# Markup Summary

# Preliminary Plan for ABERT RANCH SUBDIVISION

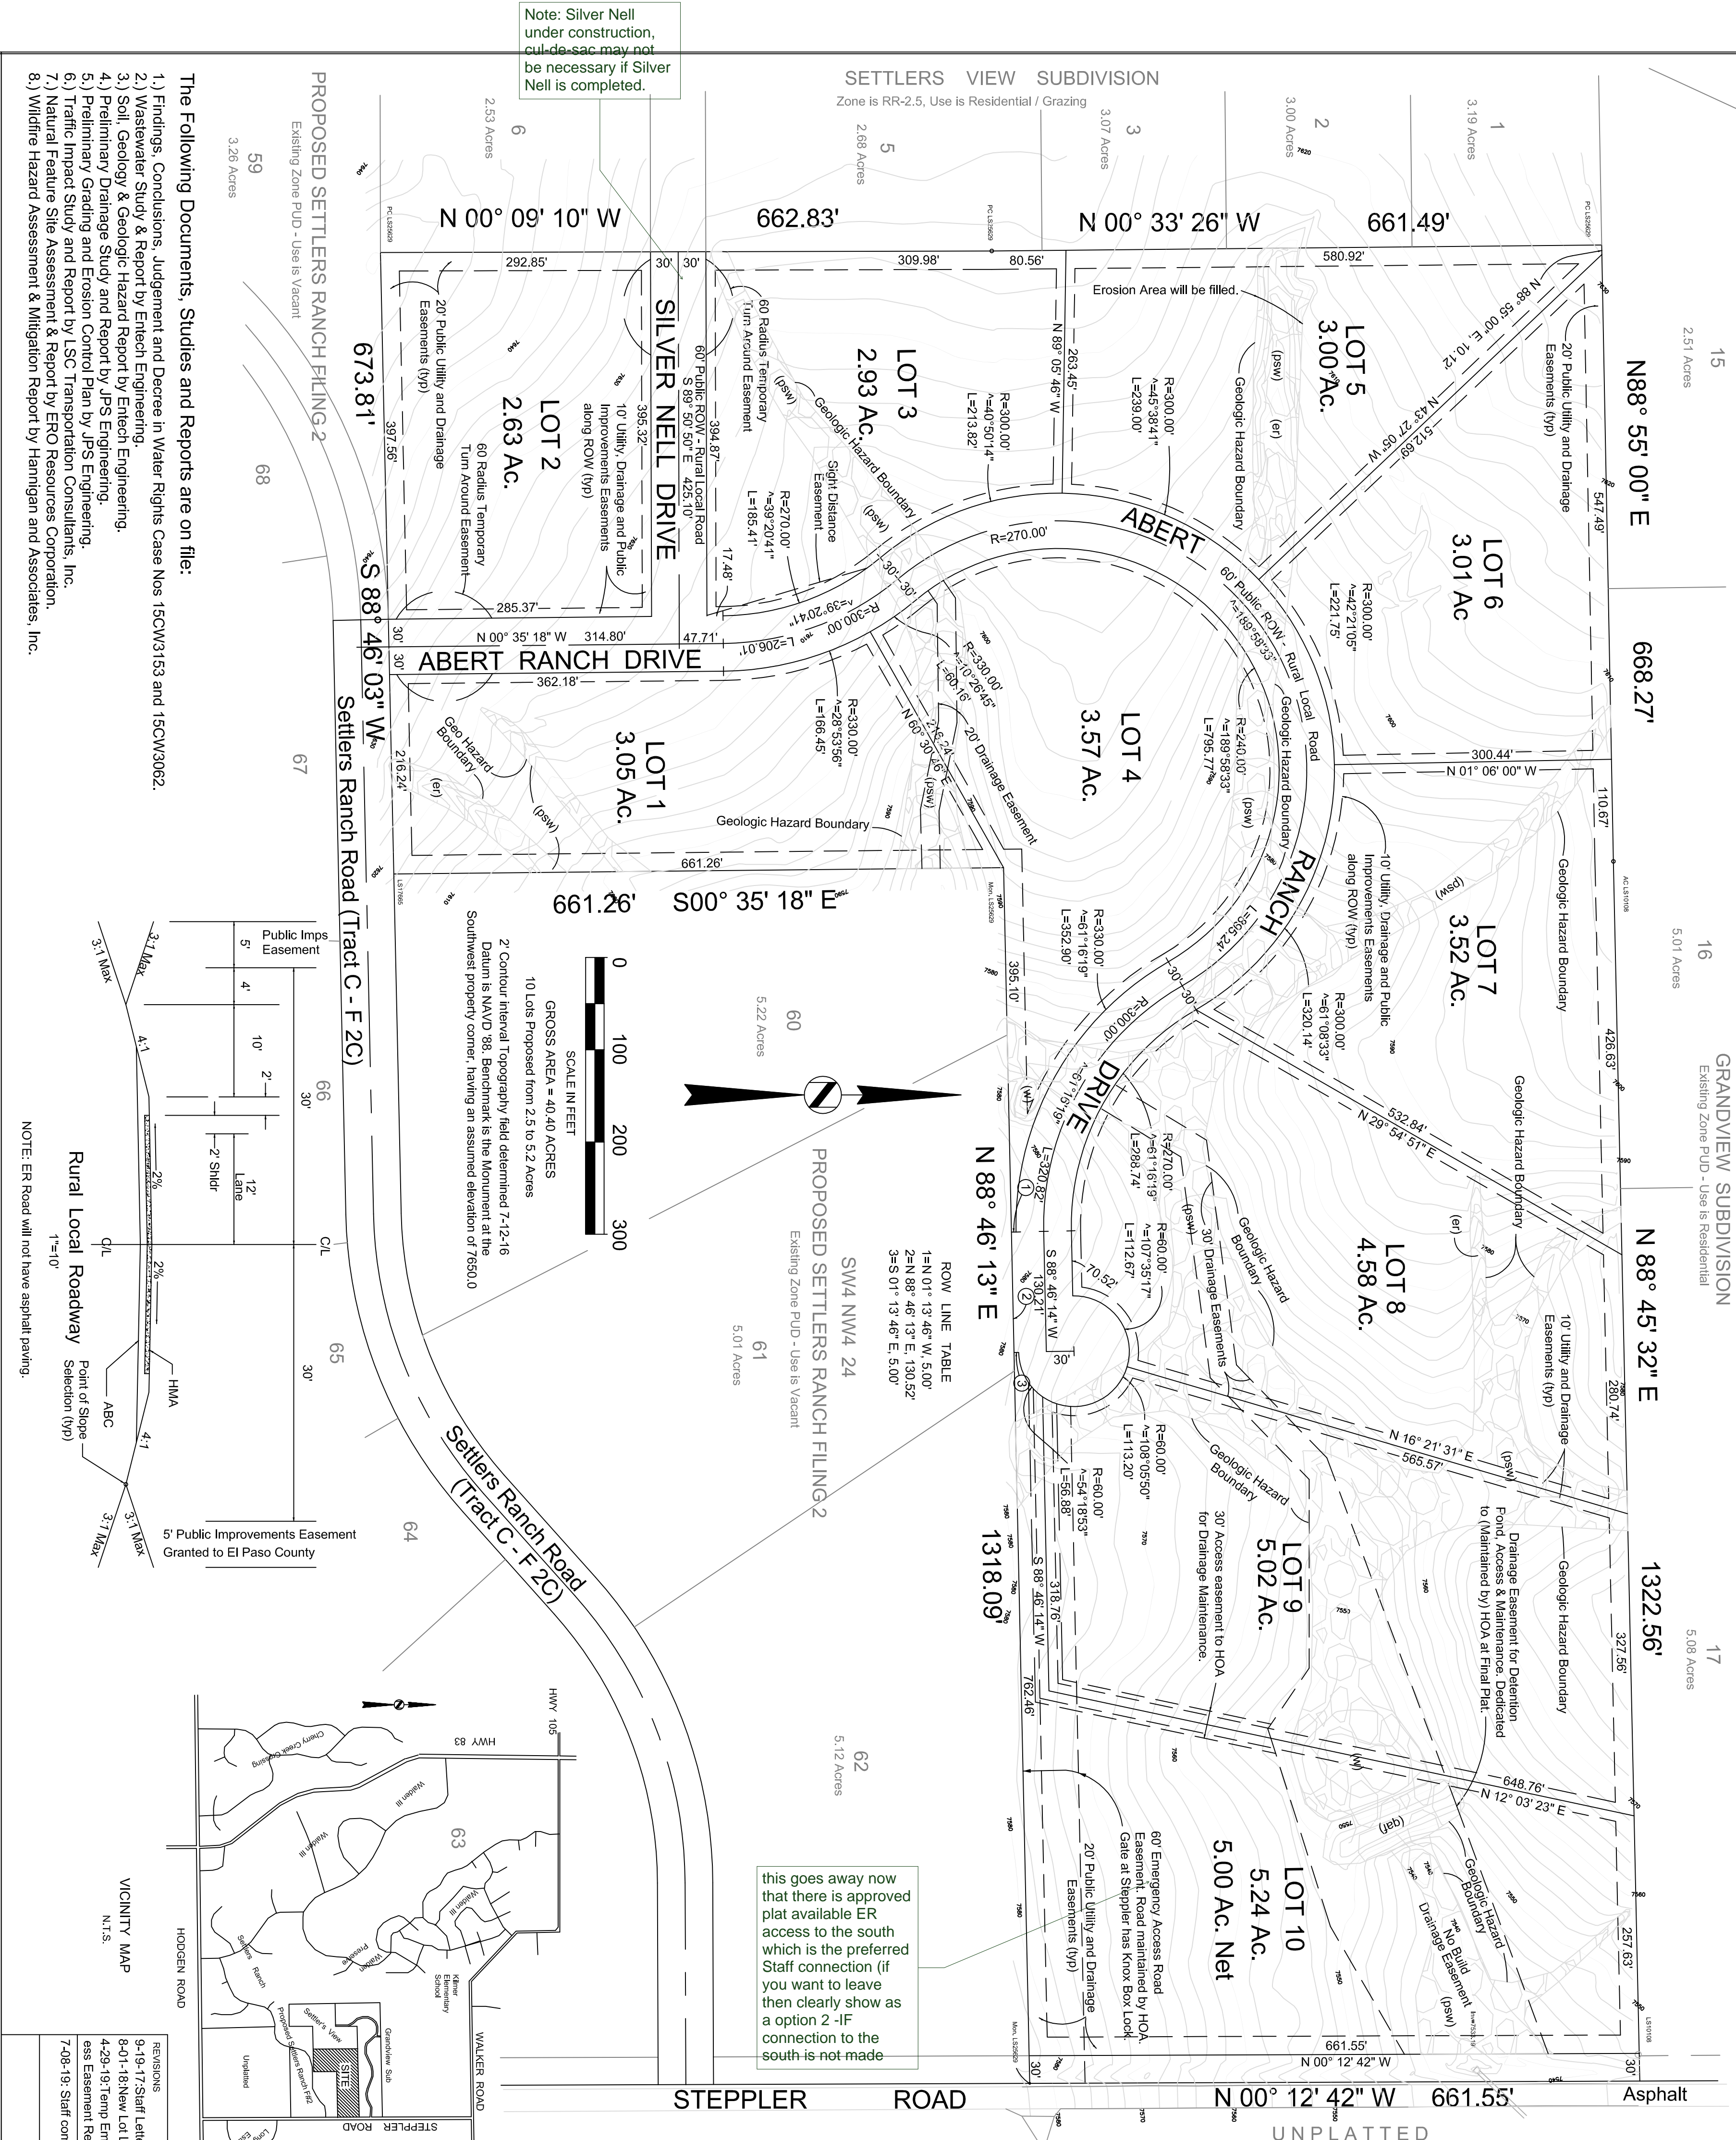
Add a legend/abbreviation list for the hatch and abbreviations.

Temporary (to be vacated upon completion of Settlers Ranch Road).

Who maintains this in the interim?

Add a typical roadway cross section detail for the Temporary Emergency Access road.  
Unresolved.

Staff suggests combining these lots as the lots are oddly shaped and have excessive frontage. This will also aide in compliance with the Black forest sub area as Abert Ranch Drive is the sub area dividing line cited.

Drainage easement to continue further upstream?
